Rezoning Transportation Analysis

Petition Number: 2025-098

From: Jake Carpenter, PE

Date	Description
9-24-25	First Review (NK)
10-23-25	Second Review (NK)
11-03-25	Trip Generation Update (DR)
11-25-25	Third Review (NK)

RZ1.00

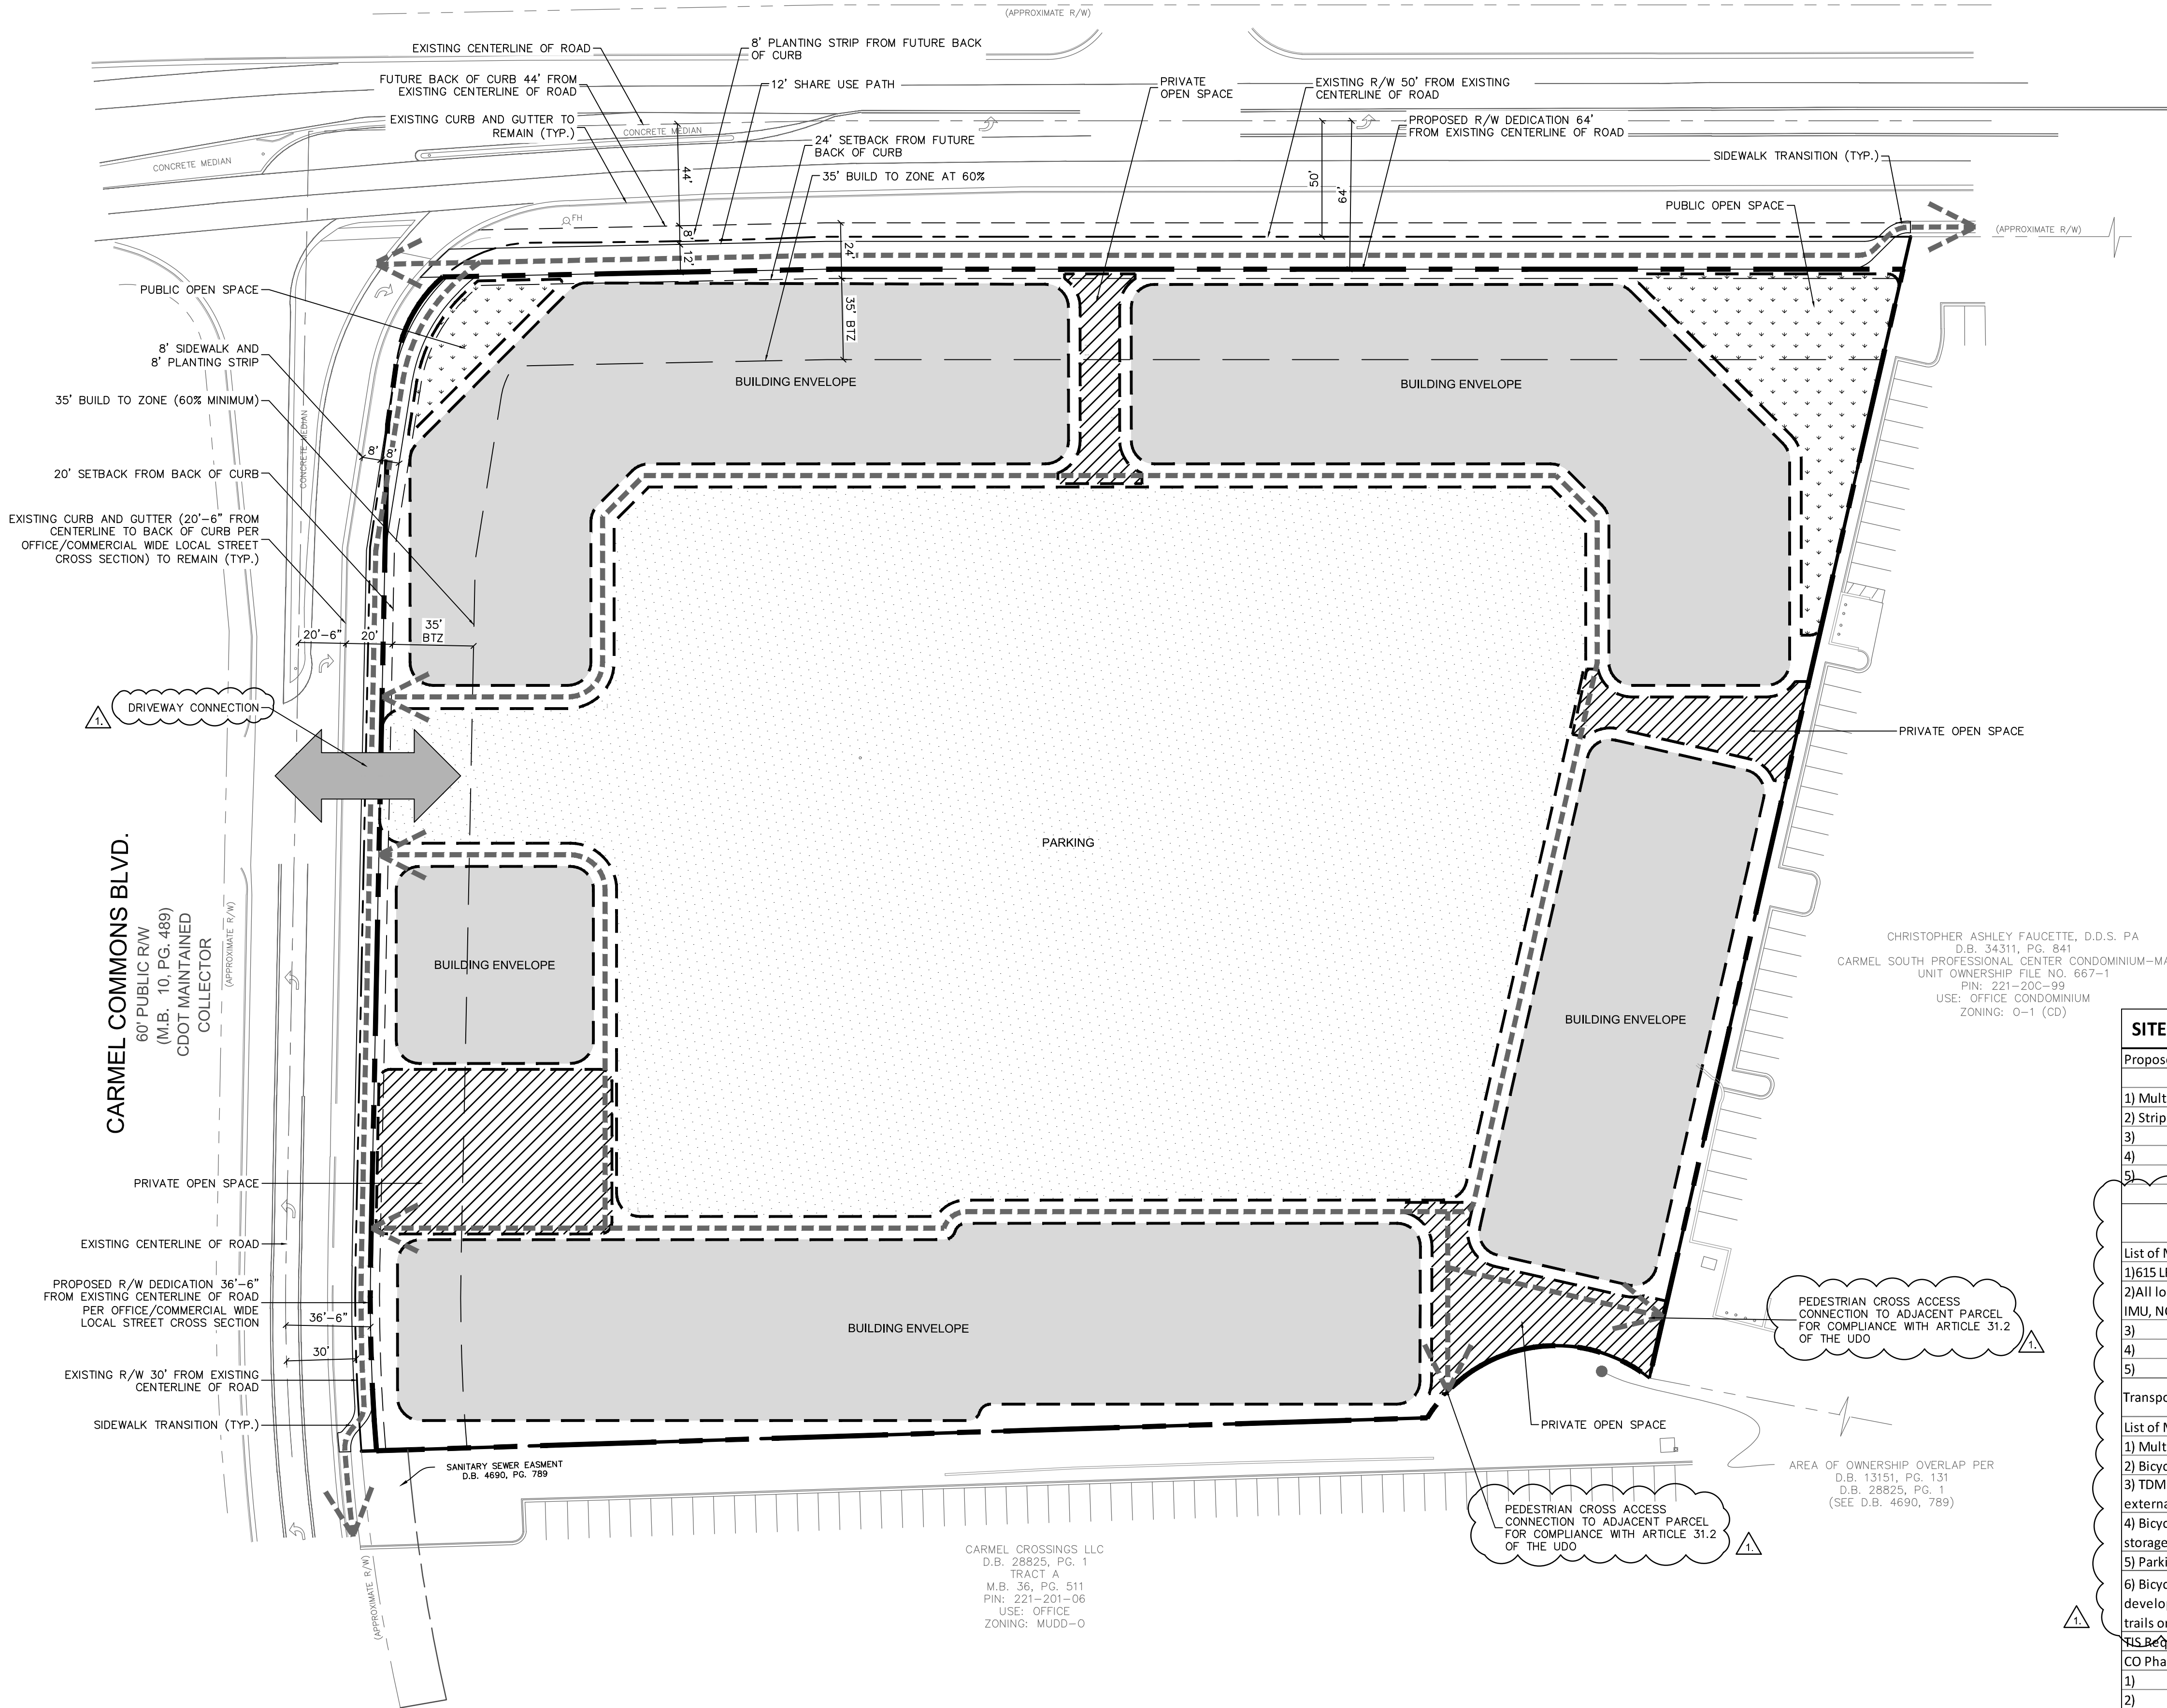
The petition's zoning falls within the medium to high intensity development which based on the 2,207 daily trips will trigger Tier 3 (14 mitigation points) for multimodal assessment and Tier 3 (6 mitigation points) for transportation demand management assessment. The petitioner shall review and assess the publicly accessible pedestrian network within 1/4 mile walking distance of the site to identify multimodal infrastructure to meet the Tier 3 (14 mitigation points) for multimodal assessment. Petitioner shall also provide transportation demand management strategies to meet Tier 3 (6 mitigation points) to reduce vehicle trips and encourage alternative modes of transportation.

Complete CTR summary table and include on the revised plan. CTR table link (use Site Data Table—CTR Summary tab): <https://www.charlottenc.gov/files/sharedassets/city/v/2/growth-and-development/documents/dev-center-fees/resources/udo-site-data-tables-curb-ramps-and-ctr.xlsx>

3. ~~Revise site plan and conditional note(s) to show proposed access location on the site plan. Site plan is to callout/identify access location(s). Add a conditional note(s) to further identify location and commit to coordination of the access design during permitting with NCDOT and CDOT.~~
4. **Outstanding Comment 10.22.25:** Revise site plan to commit to cross access stubs to both adjacent properties per UDO article 31.2. The connection will need to be a vehicular and cannot remain as pedestrian only.

Outstanding Comment From 10.25.25: Revise site plan to commit to cross access stub to South parcel adjacent to project.

Clarifying Comment 11.25.2025: The UDO requires cross access to both the adjacent parcel to the east and the parcel south. Revise conditional note to include the parcel to the south.
